December 13, 2017

Kari Parsons
Project Manager
El Paso County Development Services Department
2880 International Circle
Colorado Springs, CO 80910

Subject: Lorson Ranch East PUD/Preliminary Plan (PUDSP-16-003) Review 2

TRACTS/ OPEN SPACE AREA:

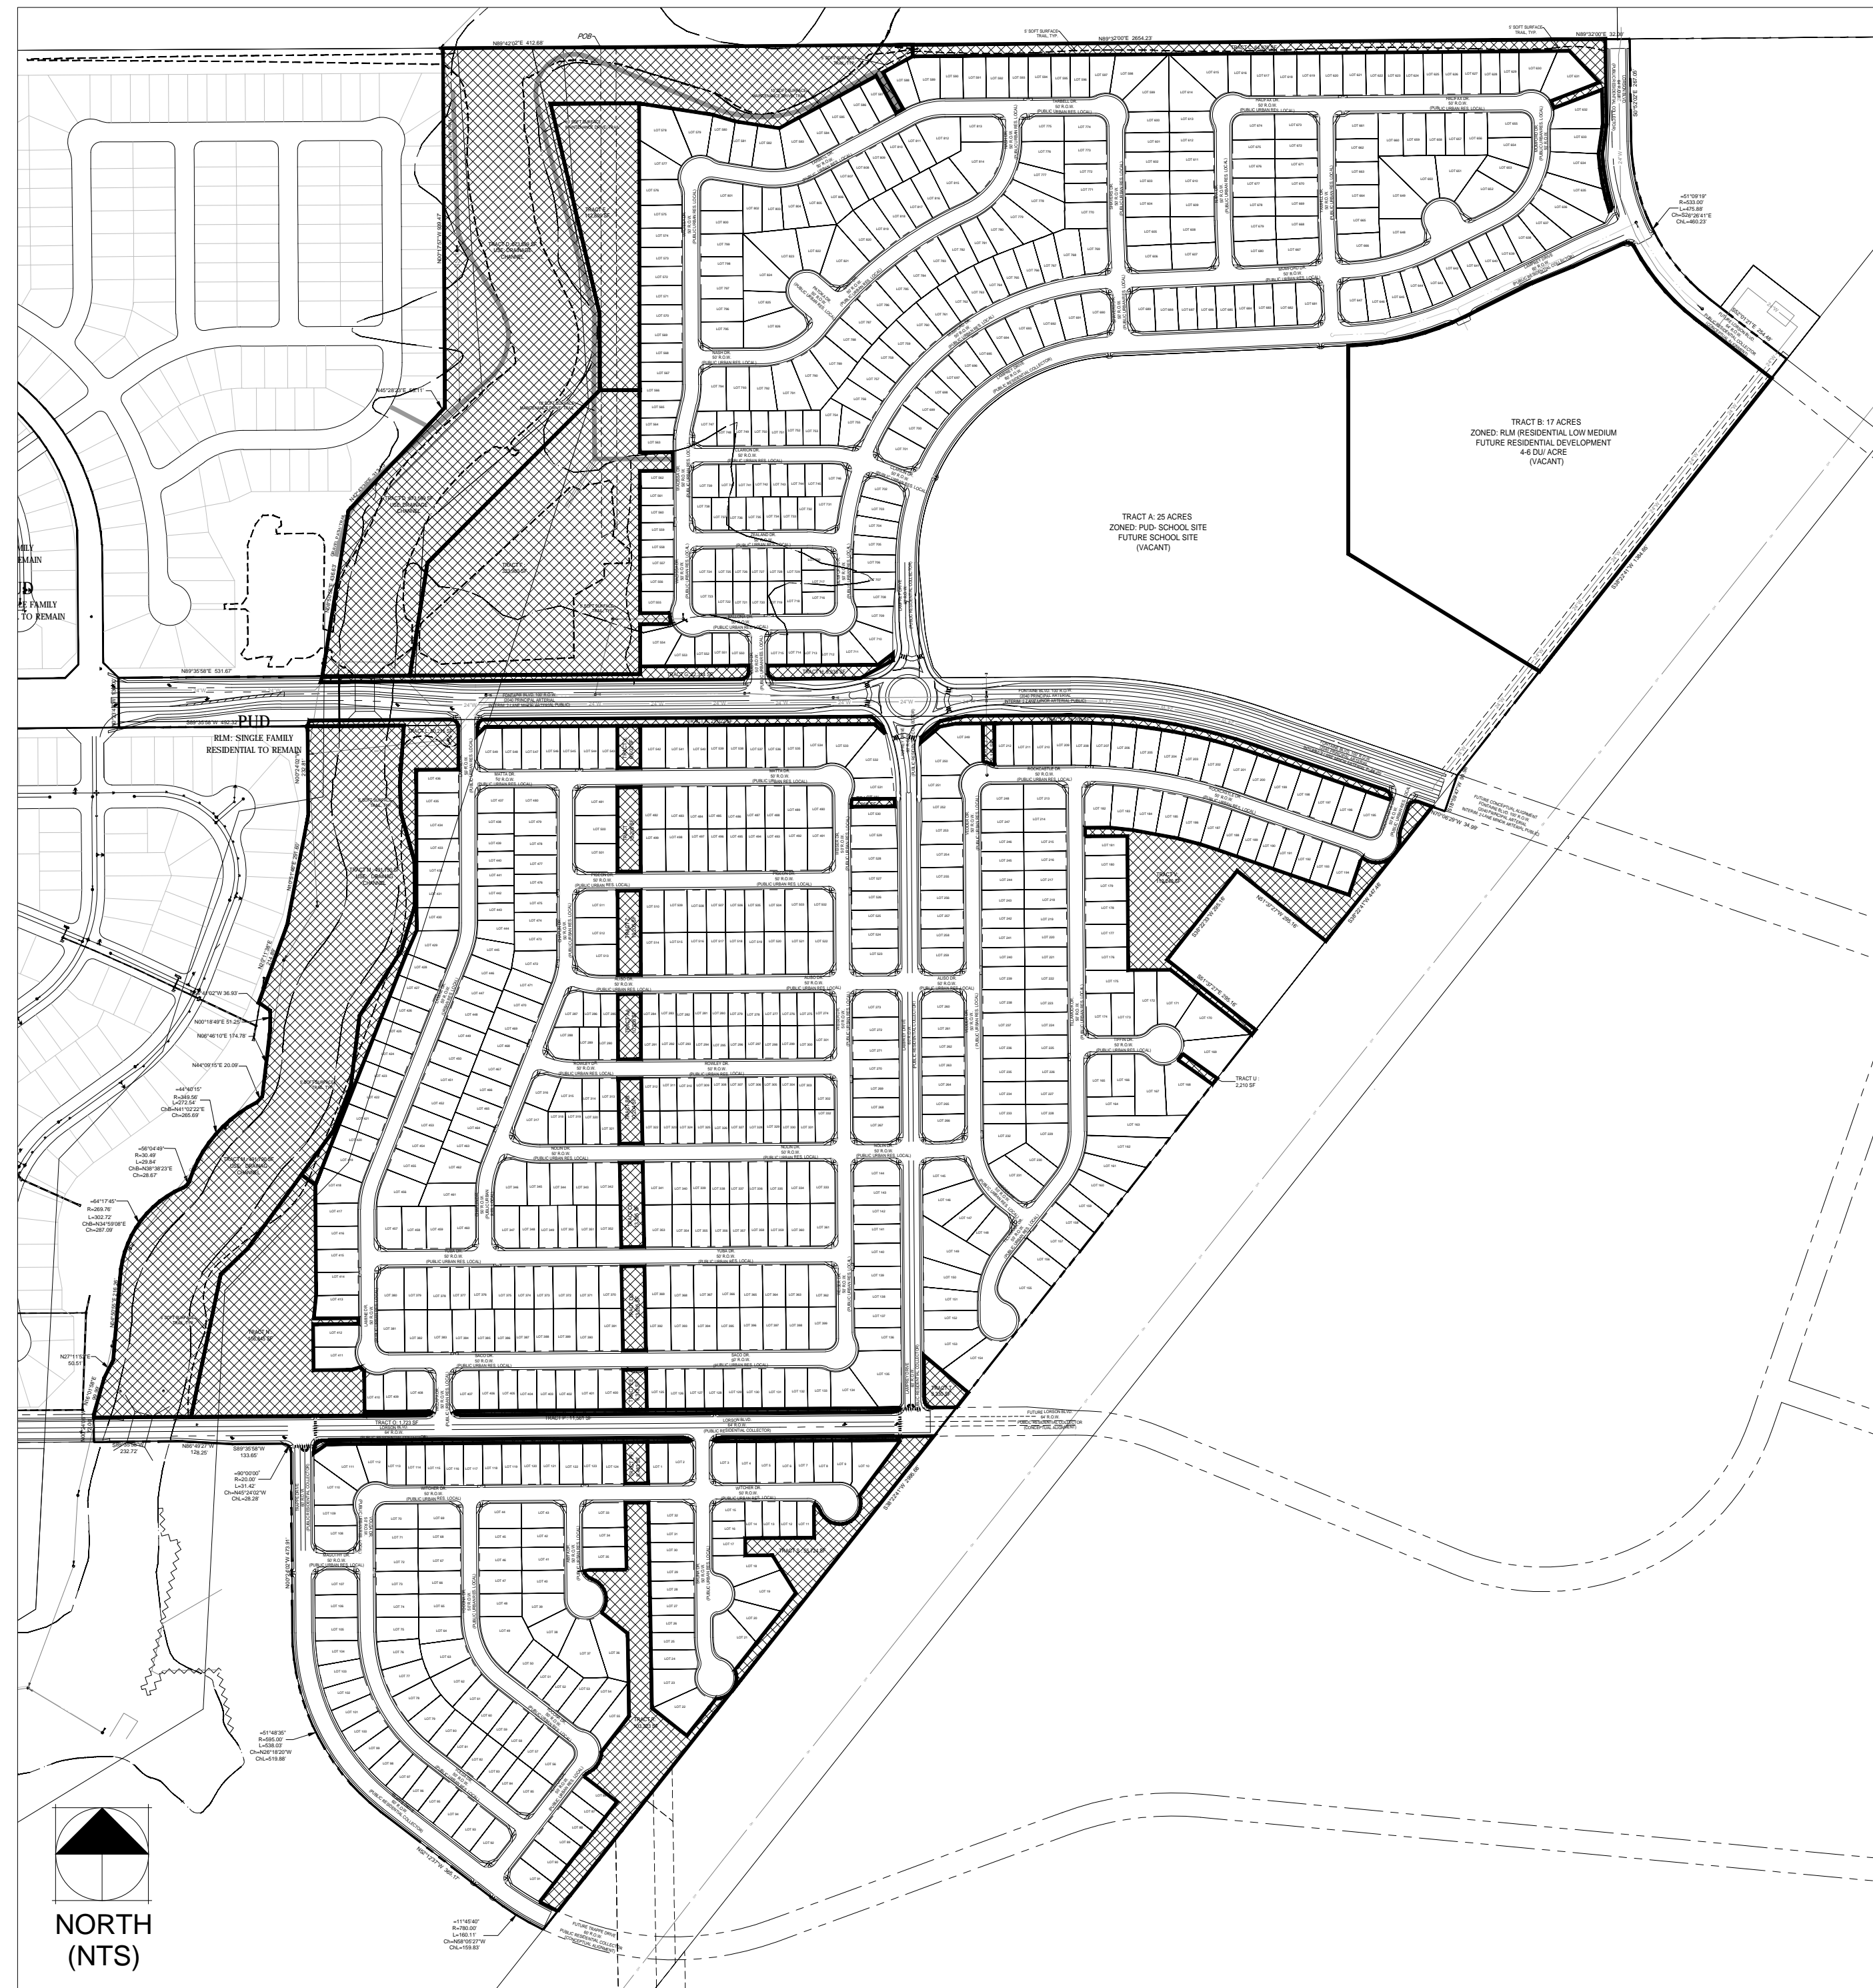
Open space dedication was adjusted and now includes 53.82 acres of open space. This is slightly down from 53.98 acres from the first application, but still exceeds the 10% minimum for open space dedication by preserving 19.6% of site as open space. Overall the revised PUDSP Review #2 application is in general agreement with the previously approved Sketch Plan (SKP-15-001).

The revised PUDSP includes a reconfiguration of open space from the approved sketch plan (SKP-15-001). This includes an open space area north of Fontaine Blvd and east of the Jimmy Camp Creek East Tributary. The applicant is now developing 3.5 acres within the previously identified open space, but is providing 6.31 acres of open space immediately northwest of the site, thus offsetting and increasing the available open space in the area.
